From: PScan1
Subject: FW: Deposit Our ref: 24/00037/F

From: Borough Planning <borough.planning@West-Norfolk.gov.uk>
Sent: 17 January 2024 16:15
To: [REDACTED]
Subject: FW: Deposit Our ref: 24/00037/F

NORTH ELEVATION PROPOSED. 1/100

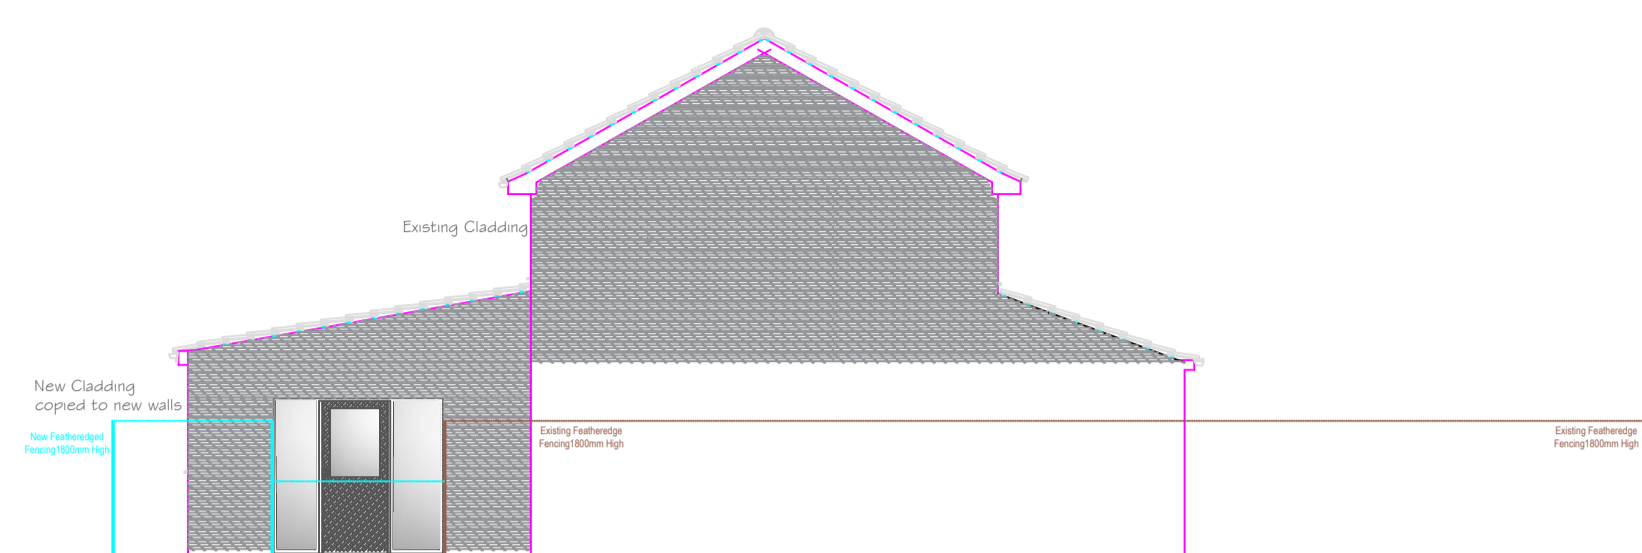
I am missing the existing and proposed north elevation. I also need a separate elevation showing the fence details. Confirm the exact position and extent of the new fence on the proposed site plan.

FRONT ELEVATION PROPOSED. 1/100

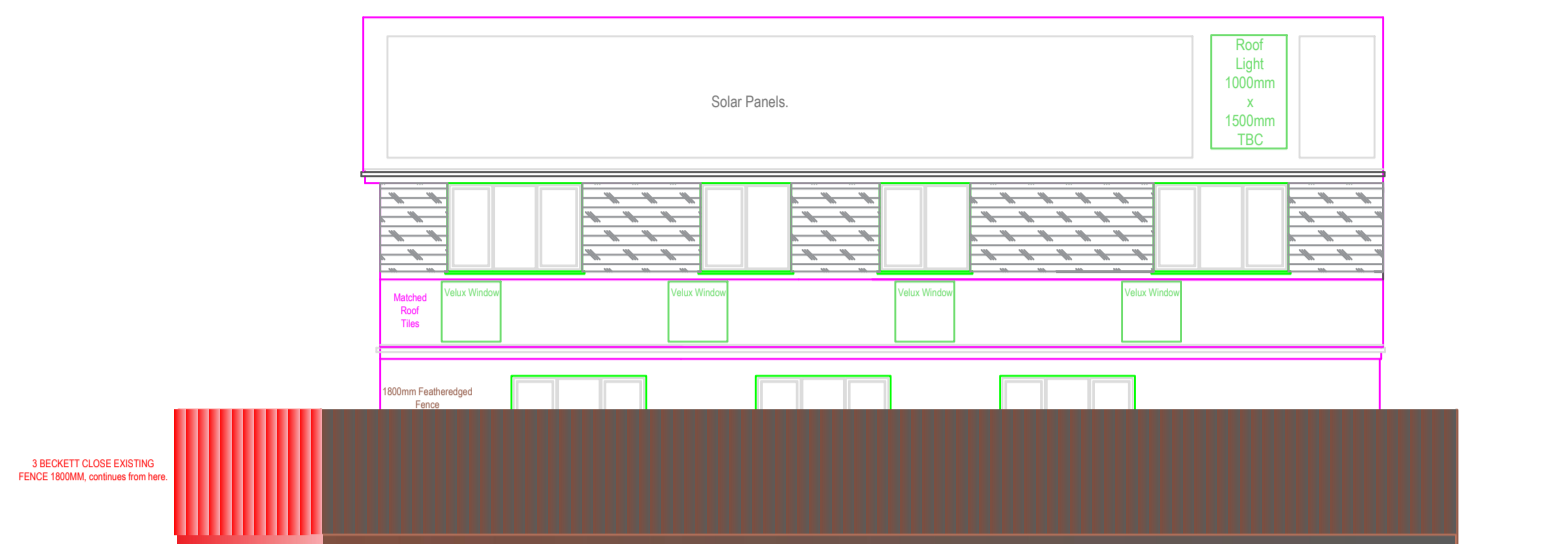
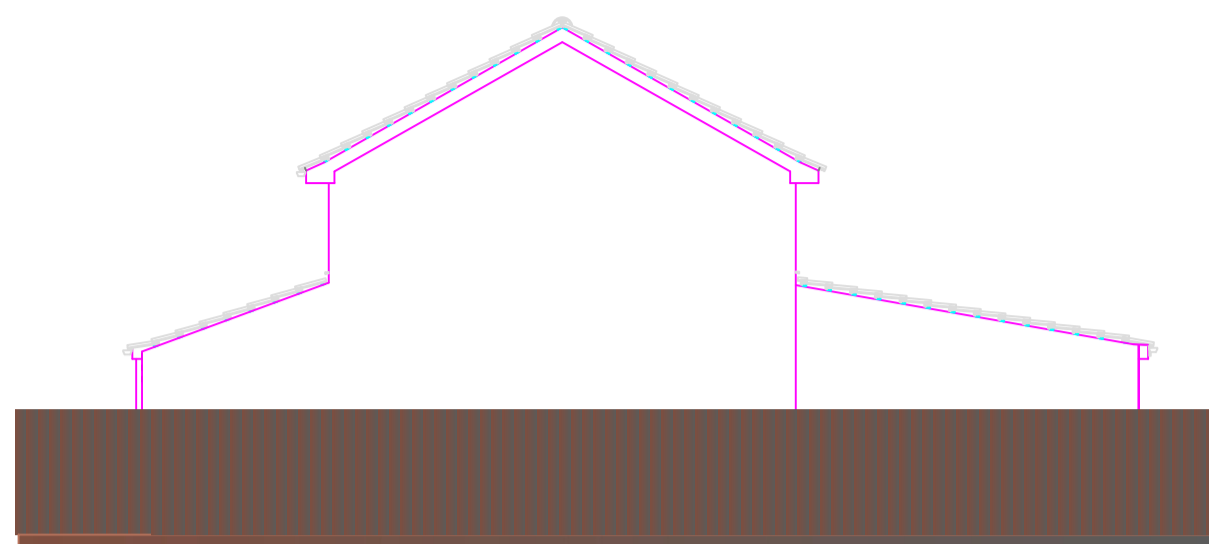
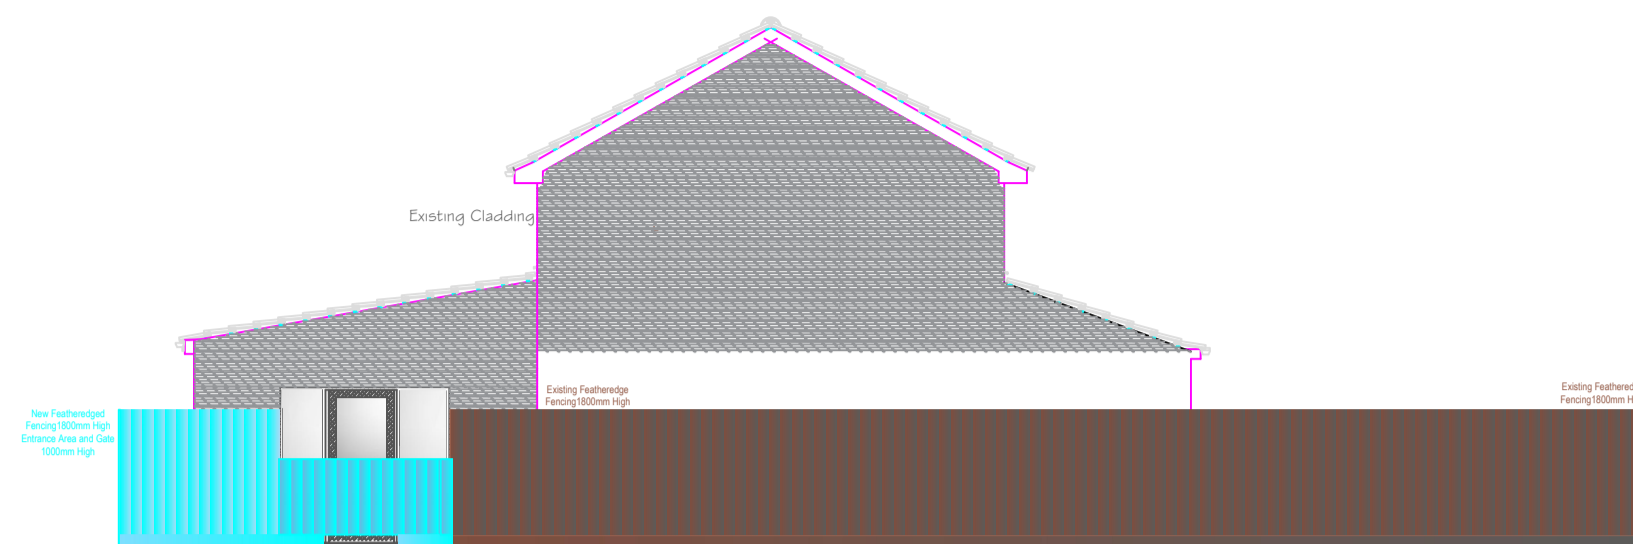
I do still require a separate scaled elevation of the fence showing the details of the fence rather than the transparent view over the front elevation.

PLAN VIEW OF PROPOSED 1/100

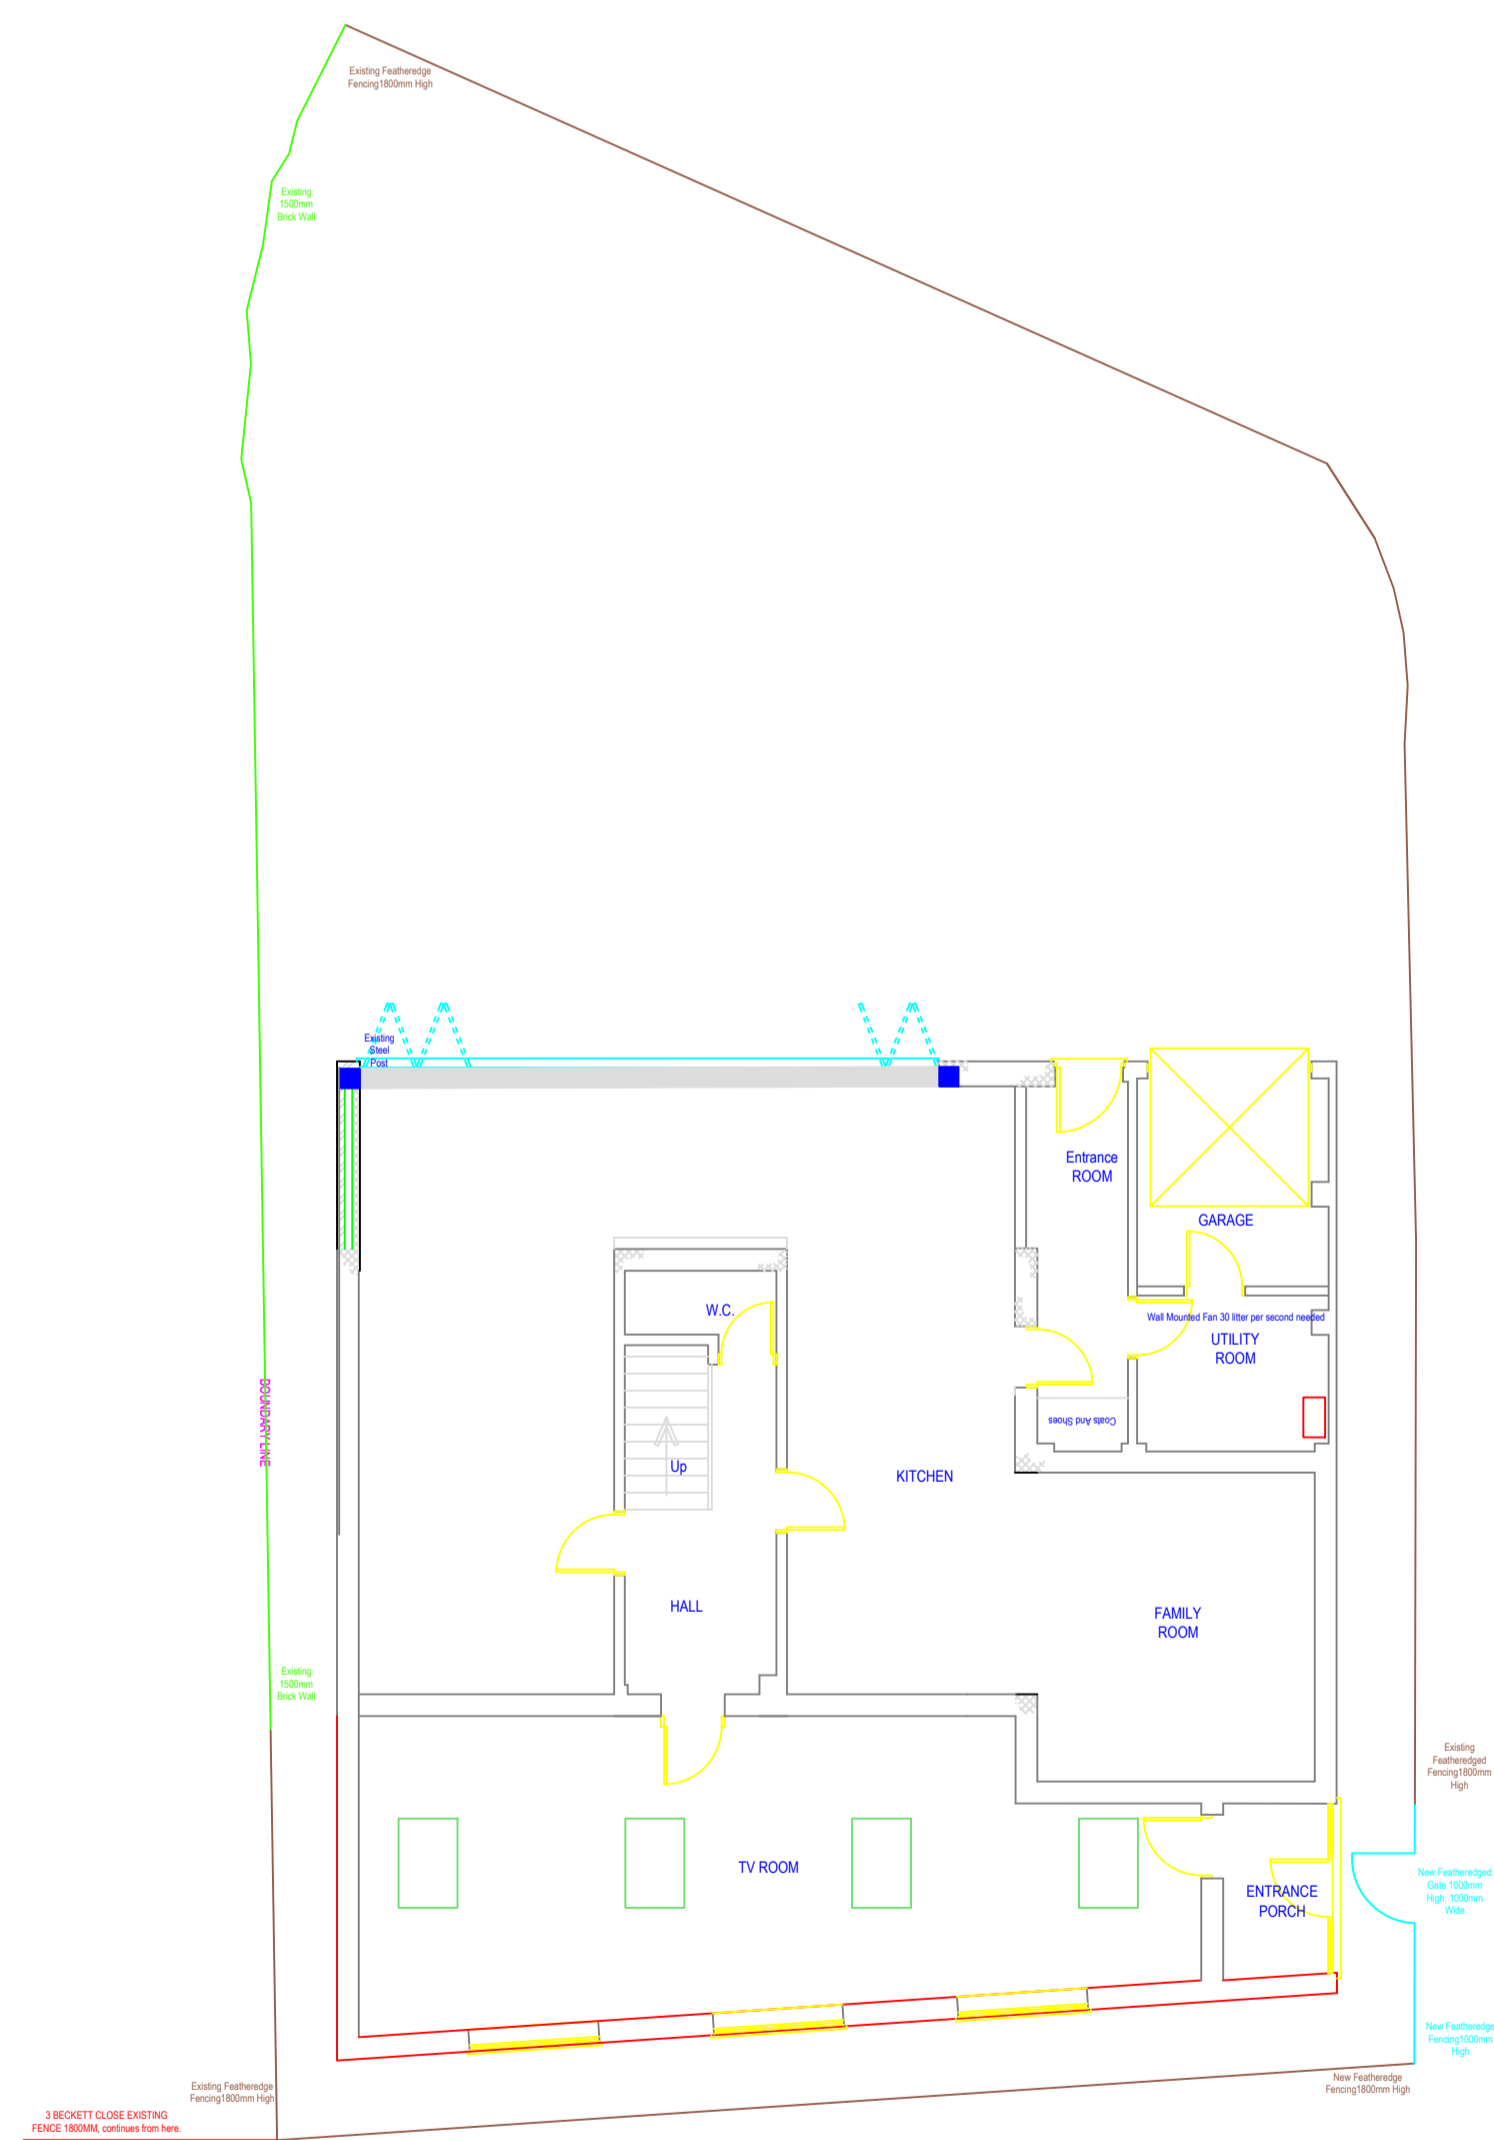
My apologies, I did forget to ask you for a block plan to a scale of 1:500 or 1:200 showing the dwelling with the extension.
